From: Ian Stocks [REDACTED] **On Behalf Of** FRS Water and Access

Subject: Planning consultation - A/110/20/RES Land South of Water Lane Angmering

WATER LANE, ANGMERING
ACCESS BRIDGE
WSCC REF: 1772
GENERAL ARRANGEMENT

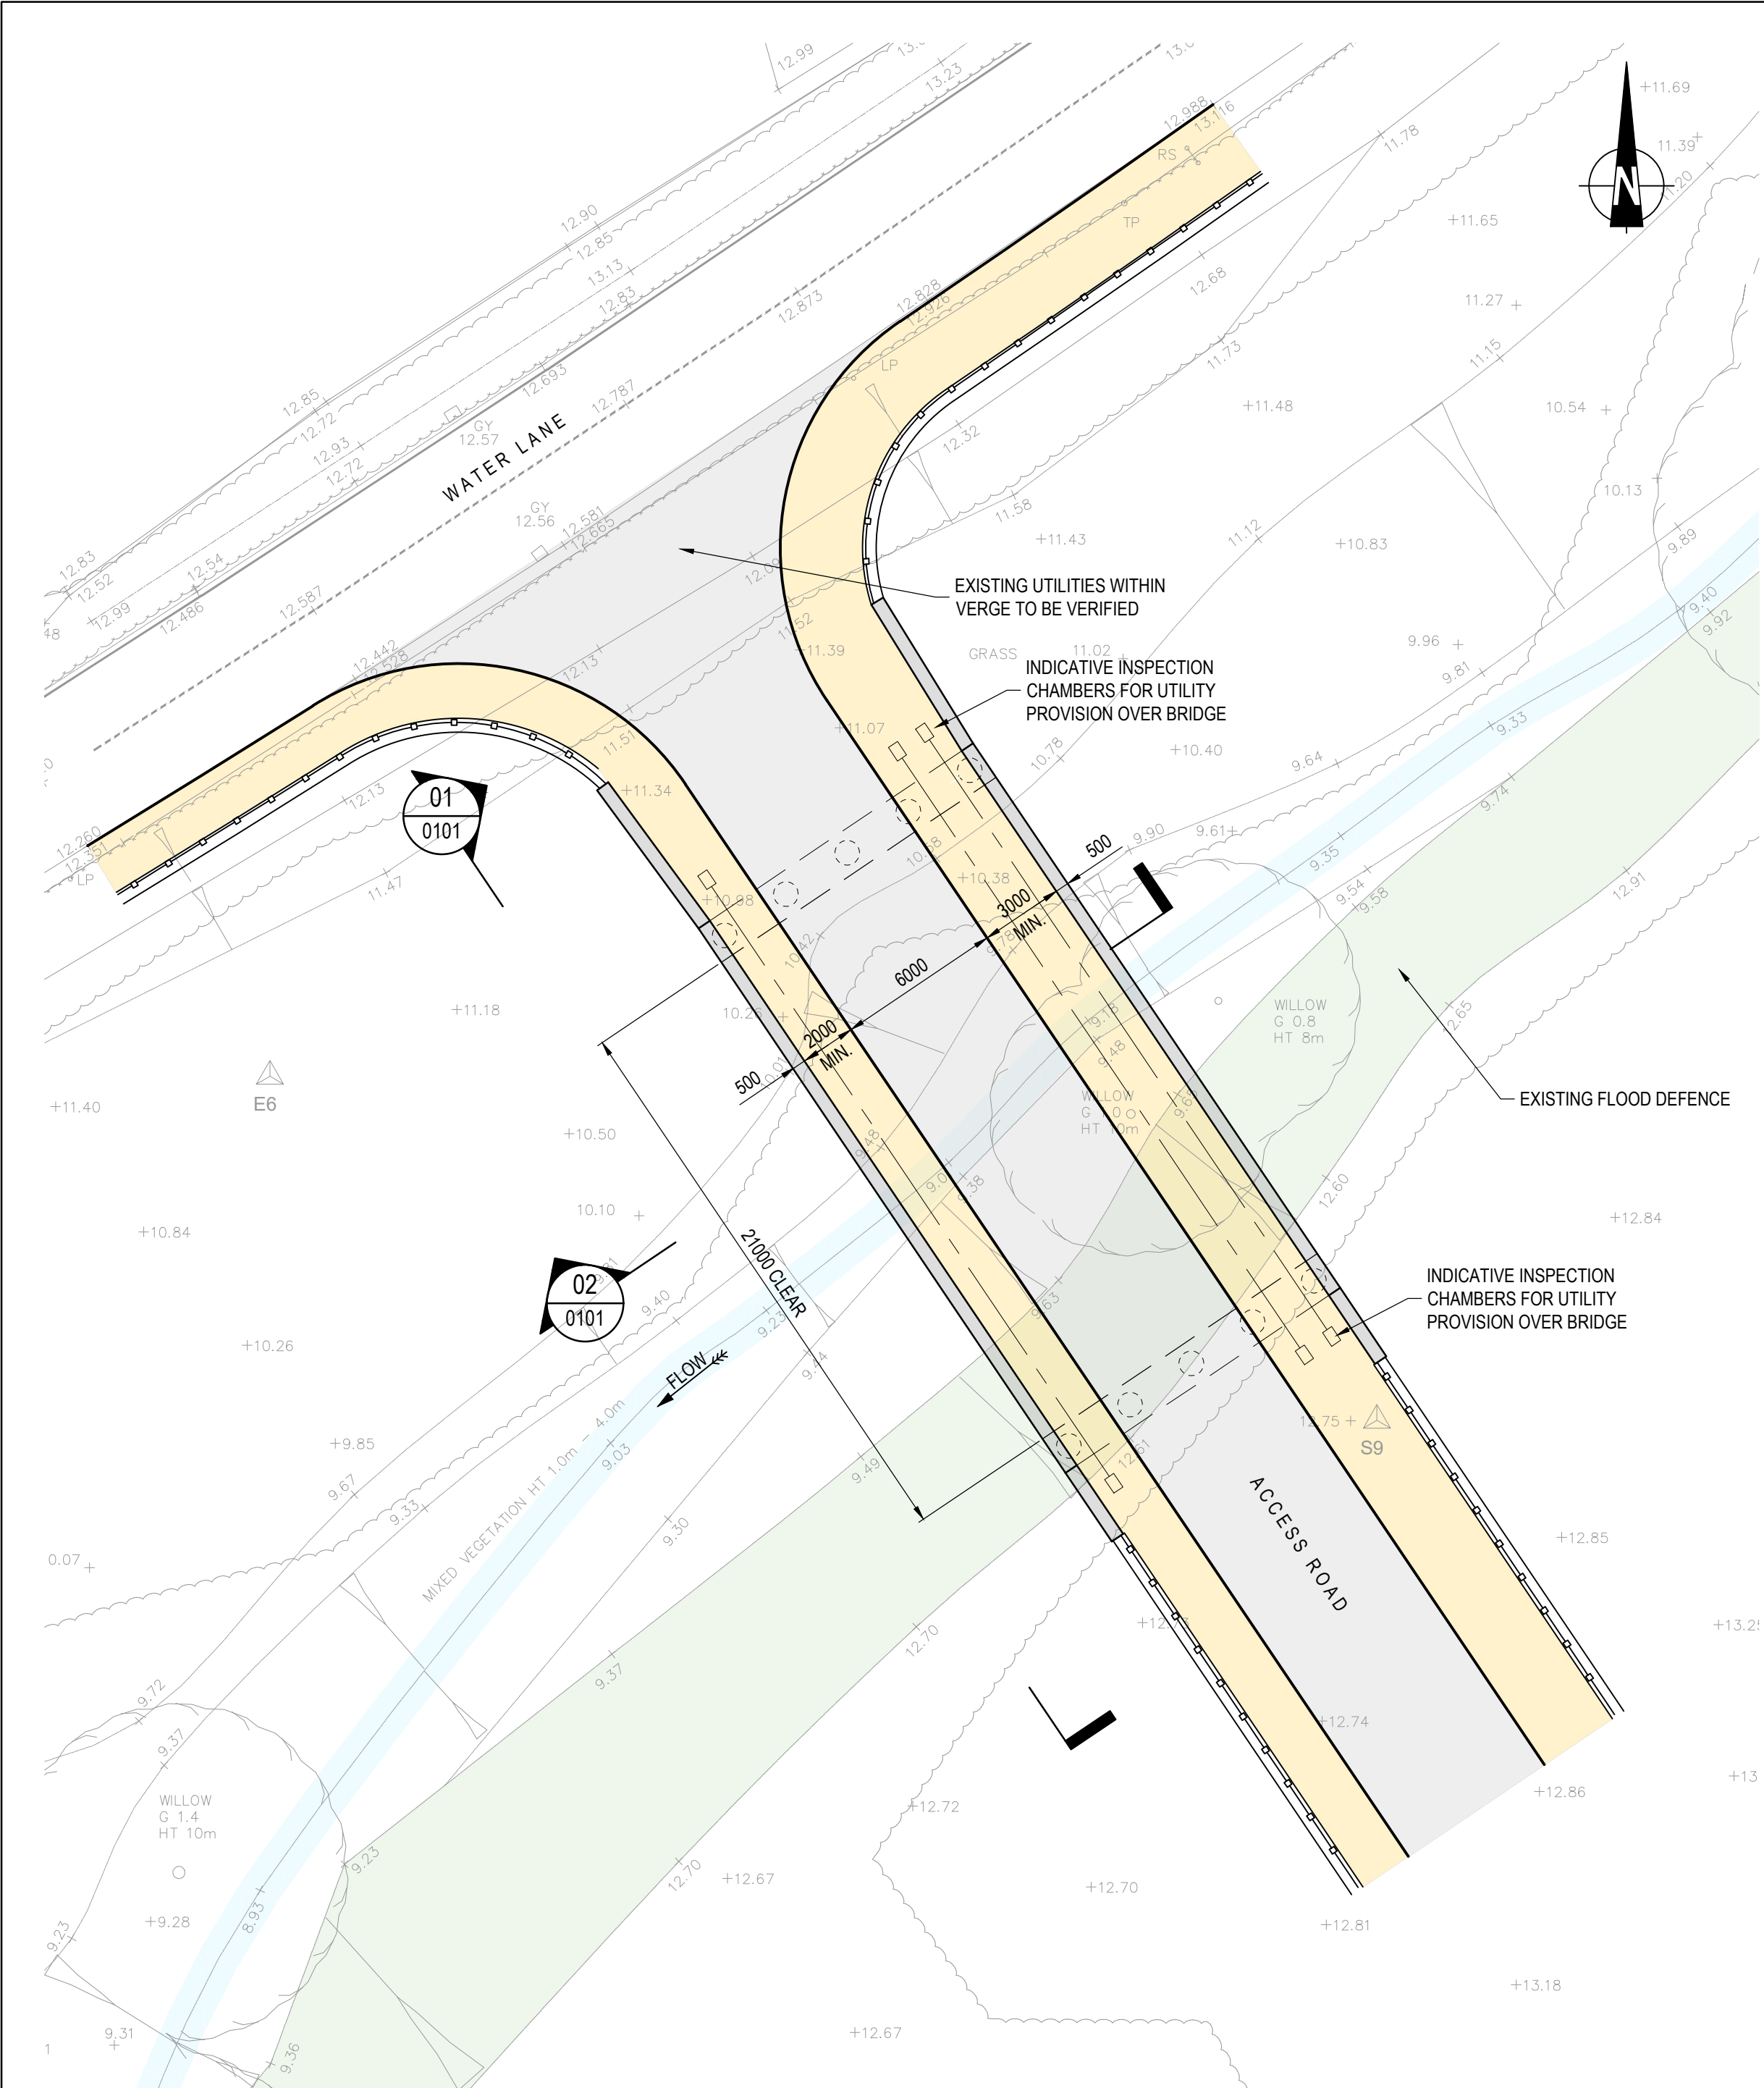
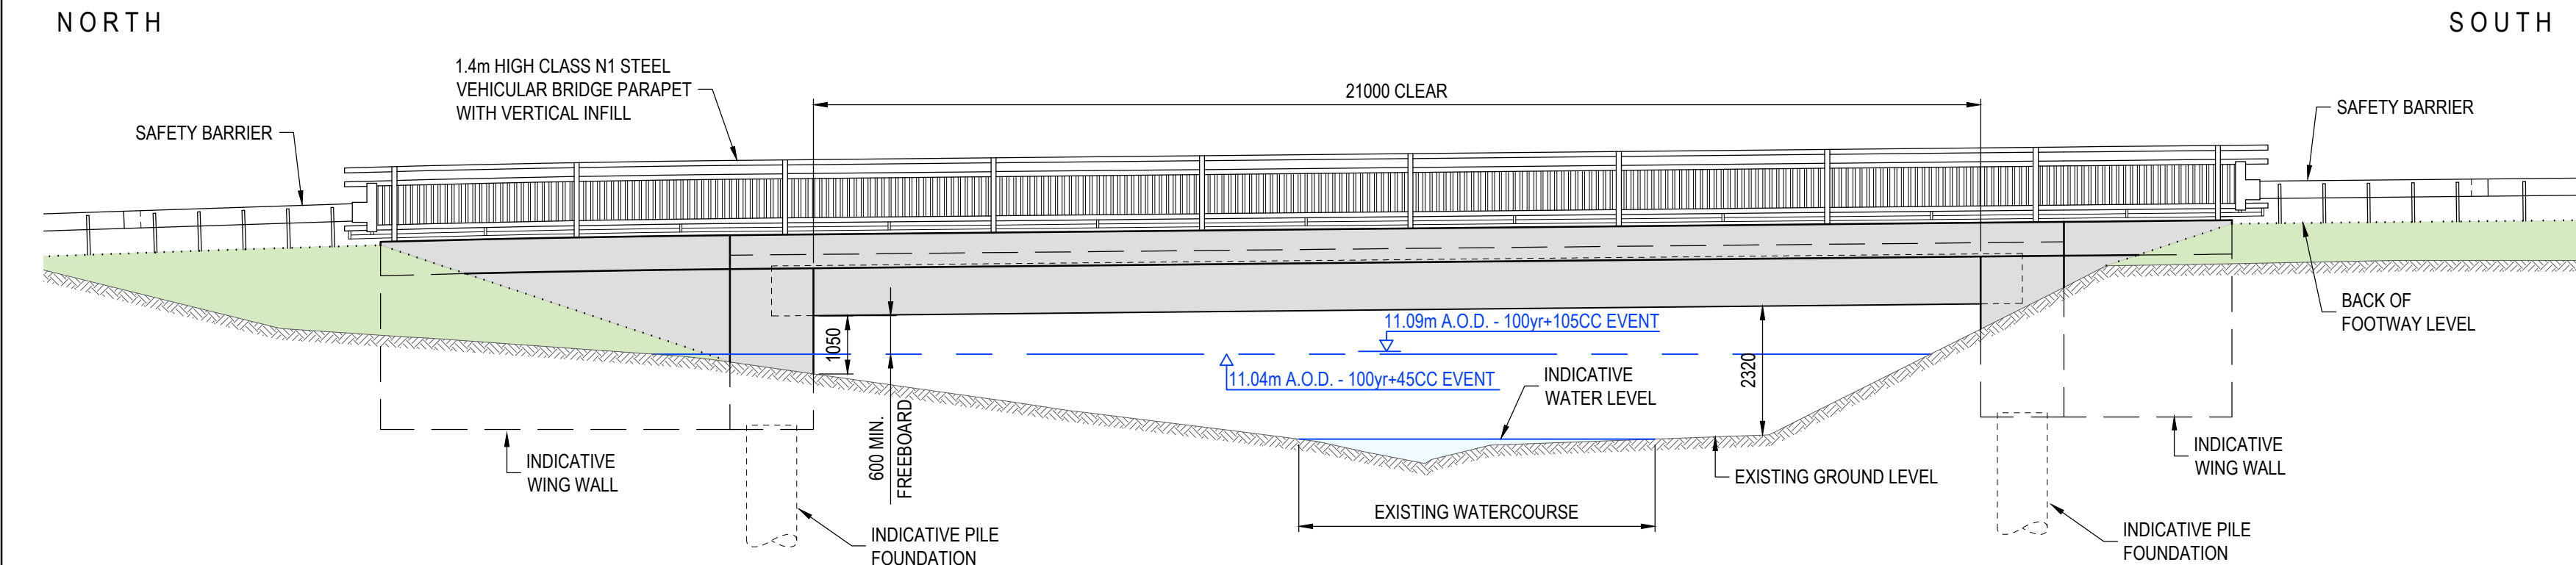
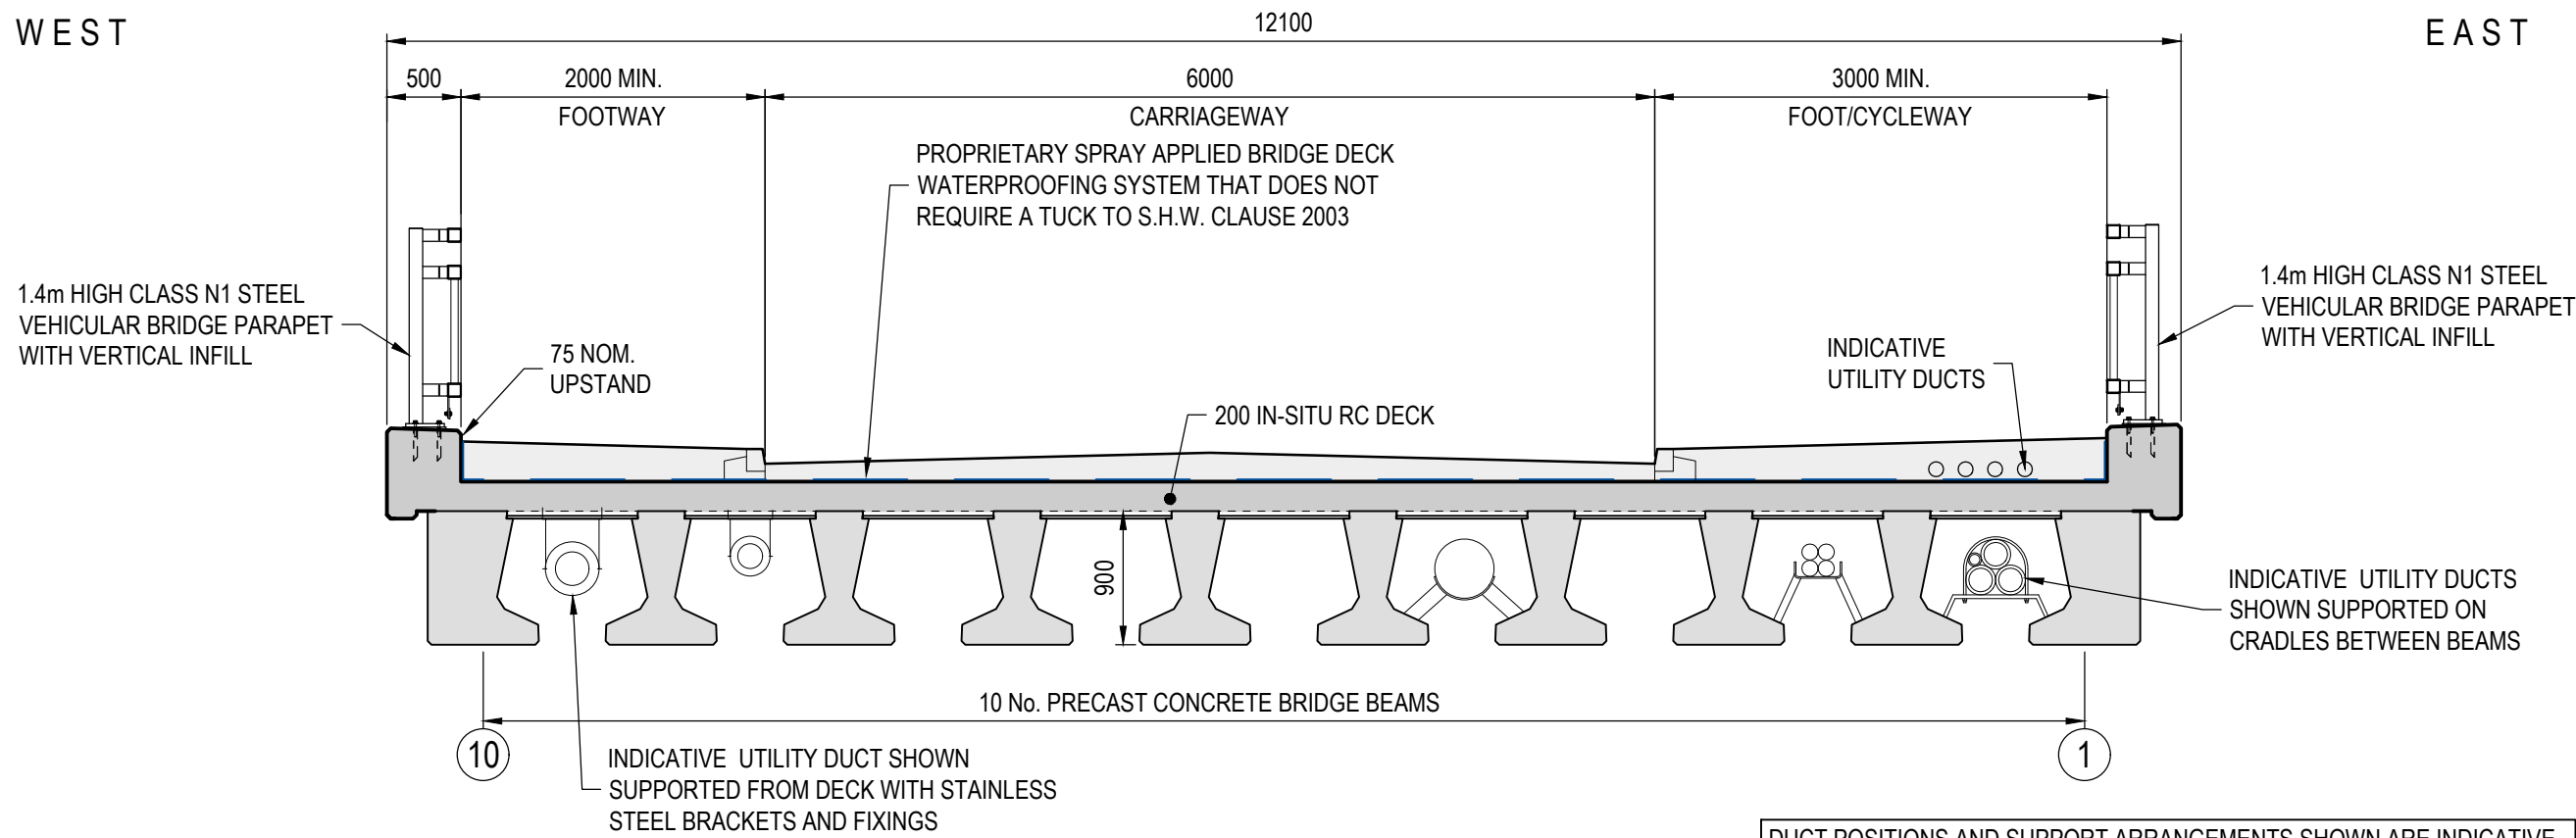
Evidence will also be required that there is sufficient access width for a fire appliance to access the site in accordance with the requirements of Approved Document – B: B5 section 13 Vehicle access. The driveway will need to be sufficiently wide enough to allow a fire appliance to gain access minimum width of 3.7 metres and 3.1 metres through a gate (AD-B Vol. 1 Table 13.1) and capable of withstanding 12 to 17 tonne axial weight.
